West Yorkshire Police
Kirklees District

Designing Out Crime Officer

To: William Simcock Kirklees Council Planning Services Civic Centre 1, High Street, Huddersfield, HD1 2NF	Ref: 2020/91611 Date: 31 st July 2020
--	---

Site Location: 92 New North Road, Edgerton, Huddersfield, HD1 5QP

PROJECT TITLE:	92 New North Road Huddersfield
DRAWING TITLE:	Proposed Carpark
DRAWN:	DRW
DATE:	07/01/2020
SCALE:	1:200
DRAWING No:	19.064/DRW/006
REVISION:	
ALL RIGHTS RESERVED, DRAWING NOT TO BE REPRODUCED WITHOUT PERMISSION. DO NOT SCALE

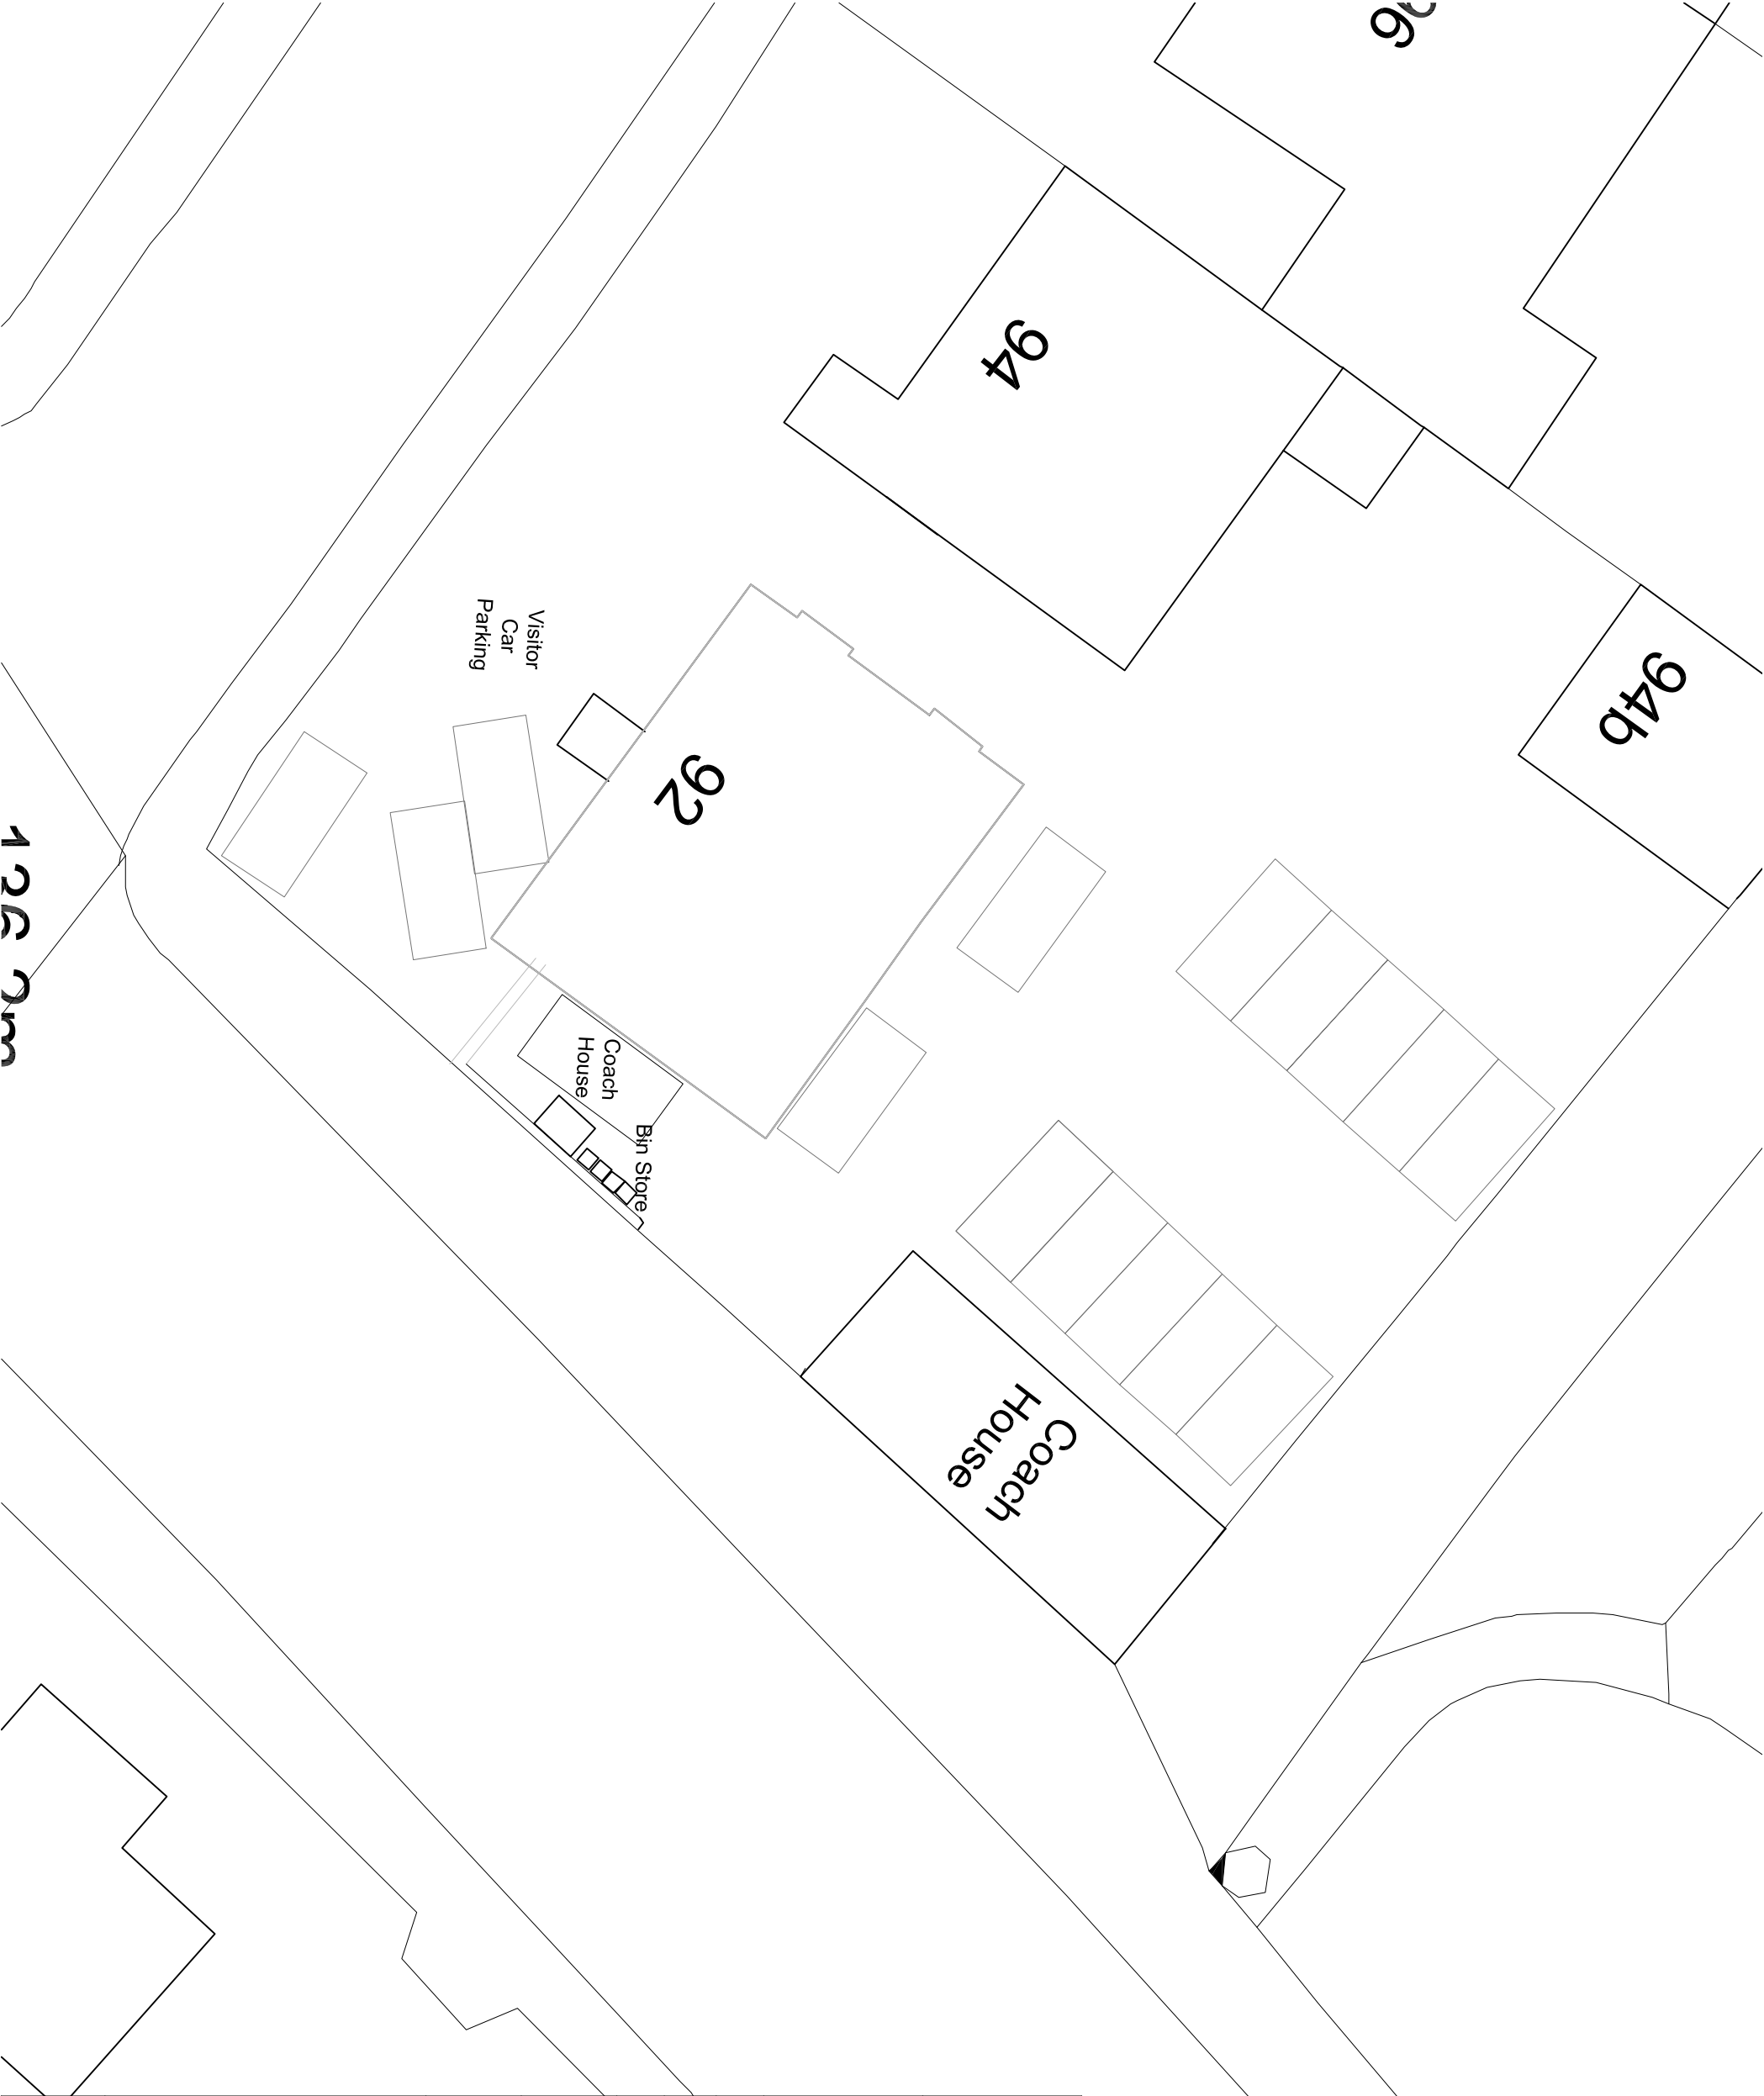
CCTV and Alarm – It is recommended that there is CCTV and an alarm system installed that covers the car park and the points of entry into the building. The siting of the cameras will have to be discussed with the Heritage Officer. Please see the below advice.

PROPOSED ALTERATIONS TO REAR ELEVATION

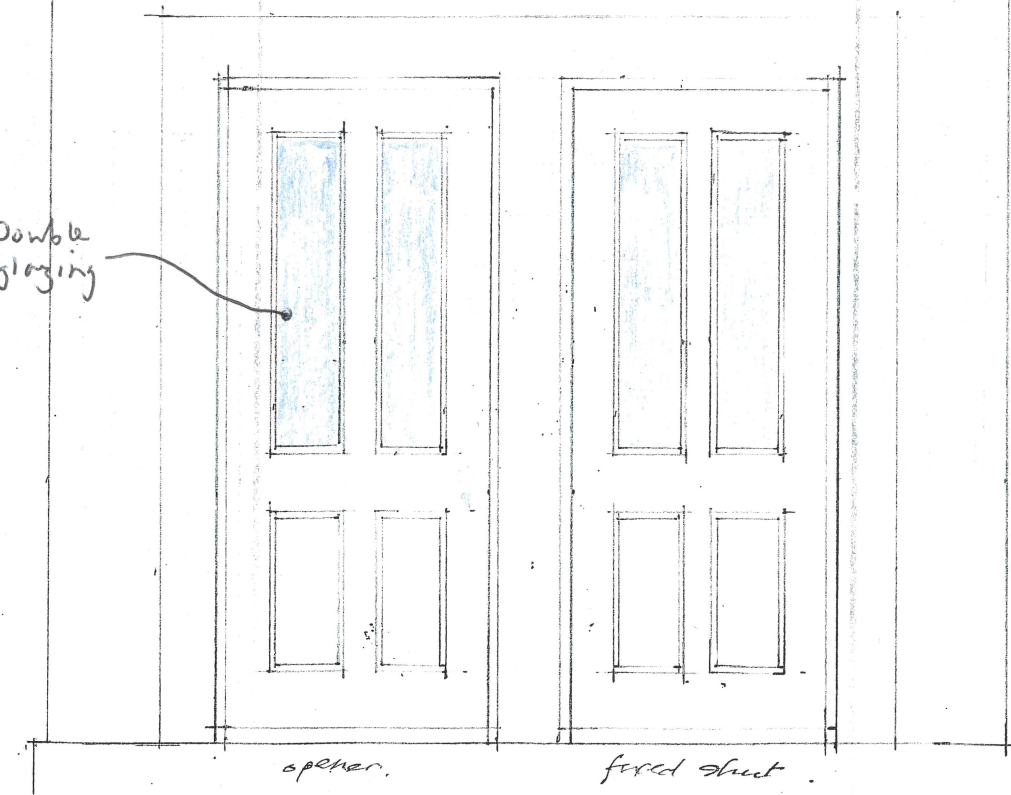
Doors – As there will be a requirement to replace the existing wooden doors. It is advised that new doors and door sets are installed to PAS24:2016 standard. There are a number of specialist suppliers and installers for heritage buildings. Details can be found on the Secured by Design website.

PROJECT TITLE:	92 New North Road Huddersfield
DRAWING TITLE:	Location Plan
DRAWN:	DRW
DATE:	07/01/2020
SCALE:	1:500
DRAWING No:	19.064/DRW/001
REVISION:	
Proposed Bicycle Stand.	
ALL RIGHTS RESERVED. DRAWING NOT TO BE REPRODUCED WITHOUT PERMISSION. DO NOT SCALE

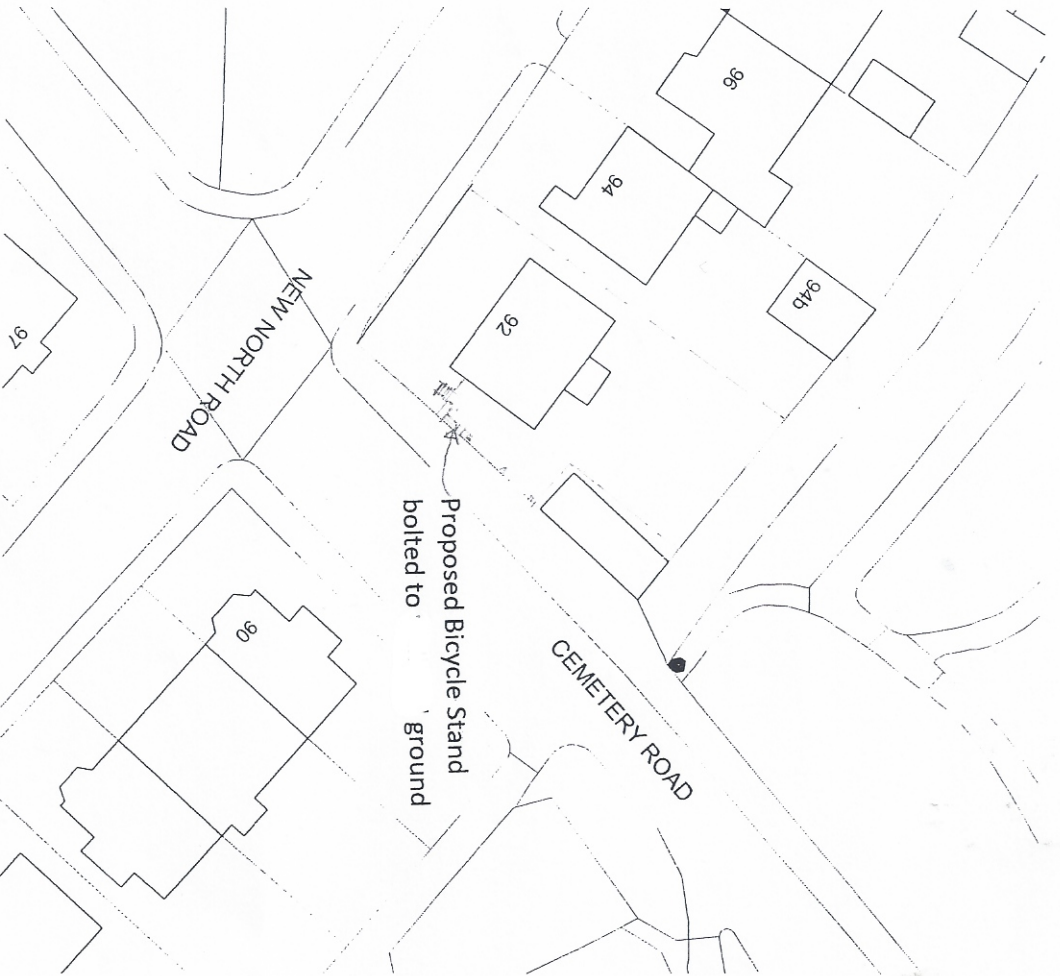
The bicycle security anchor should look to be certified to Sold Secure Silver Standard or LPS 1175 issue 8 (2019) SR1 and securely fixed to the concrete foundation.
